CITY OF ALBUQUERQUE

Re: 1st Nations Community Health Source
5608 Zuni RD SE
Traffic Circulation Layout
Engineer's/Architect's Stamp XX-XX-XX (L18-D047)

Based upon the information provided in your submittal received 12-09-16, the above referenced plan cannot be approved for Building Permit until the following comments are addressed:

**AS-TCL**

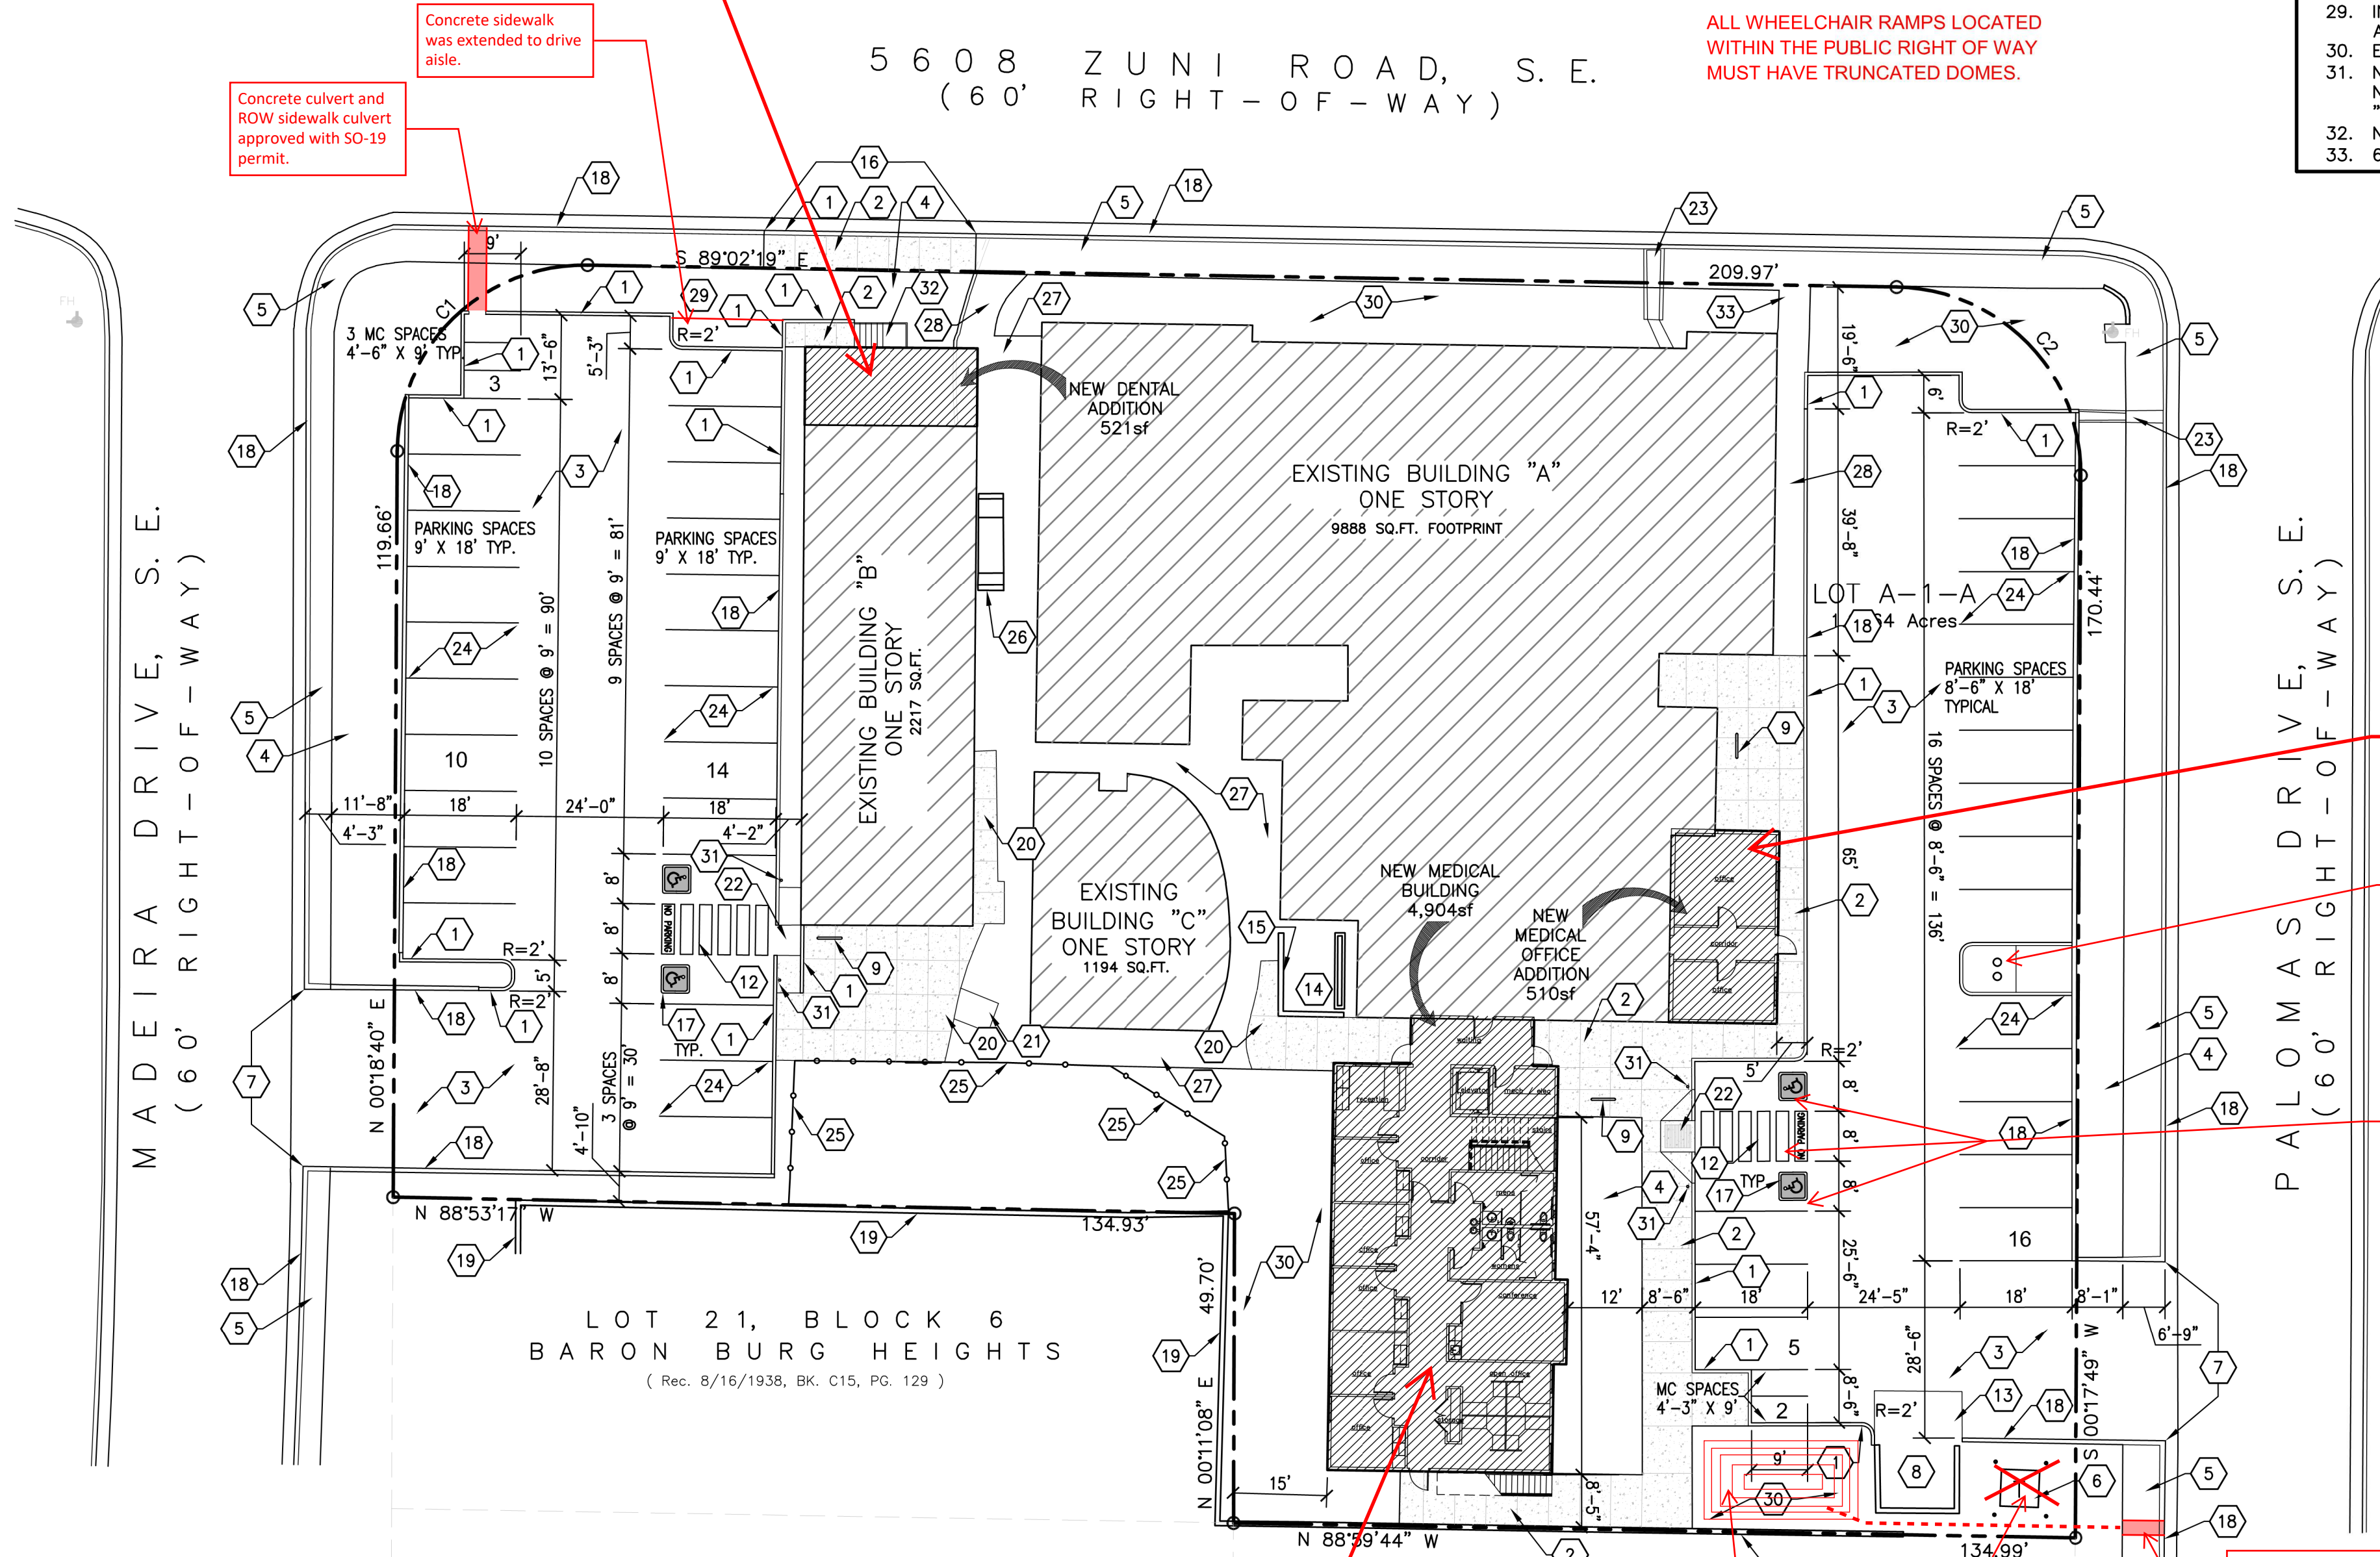
1. The traffic circulation layout must be stamped, signed, and dated by an engineer or architect licensed in the state of New Mexico.
2. The ADA accessible parking sign must have the required language per 66-7-352.4C NMSA 1978 **"Violators Are Subject to a Fine and/or Towing."** Please call out detail and location of HC signs.

3. The ADA access aisles shall have the words **"NO PARKING"** in capital letters, each of which shall be at least one foot high and at least two inches wide, placed at the rear of the parking space so as to be close to where an adjacent vehicle's rear tire would be placed. (66-1-4.1.B NMSA 1978)

4. The ADA parking space has a clearly visible, blue, International Symbol of Accessibility painted on the pavement at rear of the space (66-1-4.1.E NMSA 1978) or MUTCD recommends a white symbol on a blue background.

5. Please specify the City Standard Drawing Number when applicable. Use Standard curb and gutter 2415A to close the driveway.
6. On-Street parking credit to fulfill zoning's parking requirement must be requested and approved by the Traffic Engineer, Racquel Michel prior to TCL approval. The application requires at least 45 working days. On-street parking credit is based on available parking along public right-of-ways fronting the property. The business will only be granted 50% credit for available street parking.
